**Application Ref:** 3/2016/0497

**DELEGATED ITEM FILE REPORT:**

**Development Description:** Proposed single storey extension to form kitchen, summer snug and alterations to existing barn to form guest accommodation

**Site Address/Location:** Lower Yew Tree Farm Alston Lane Preston PR3 3BN

Drawing Title
Proposed Plans and Elevations

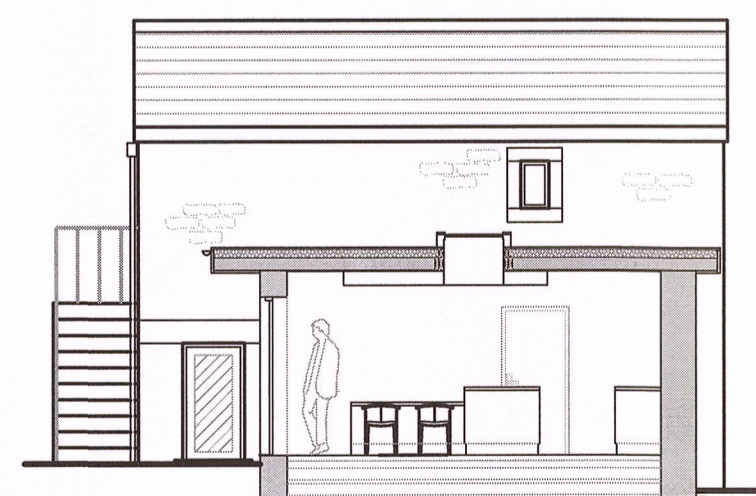
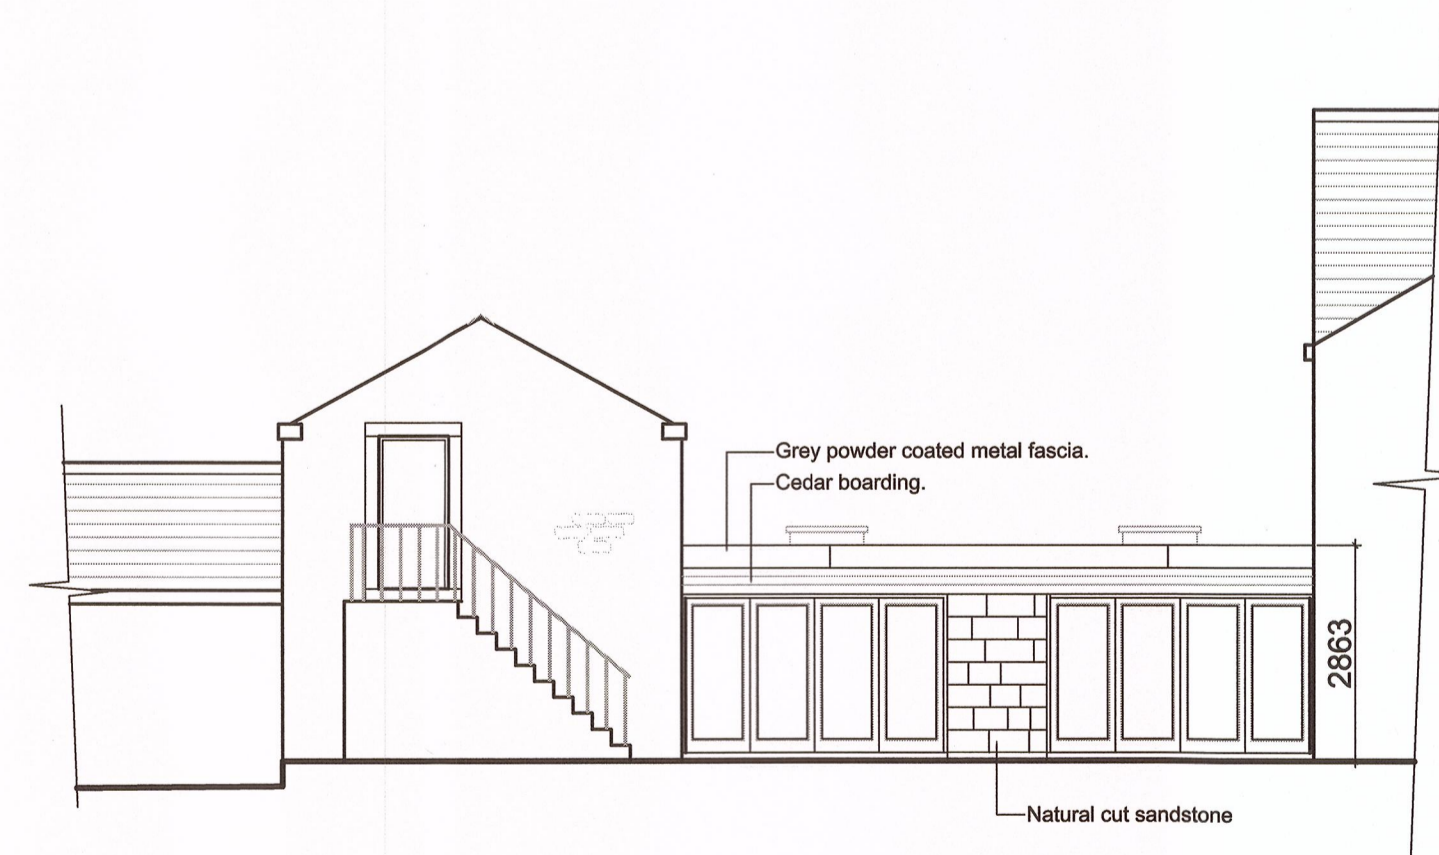
Longridge Town Council: Objection as proposed flat roof is inconsistent with vernacular housing.

In terms of design, the proposed single storey extension would be commensurate to the scale of the main dwelling. It is proposed to use natural cut sandstone, cedar boarding, grey powder coated metal fascia, polyroof and timber window frames and doors. It is considered that these materials would maintain coherence between the main dwelling and the proposed development. It would not result in any harm to the appearance of the host dwelling or the surrounding area and would accord with Ribble Valley Core Strategy Policies DMG1 and DMH5.
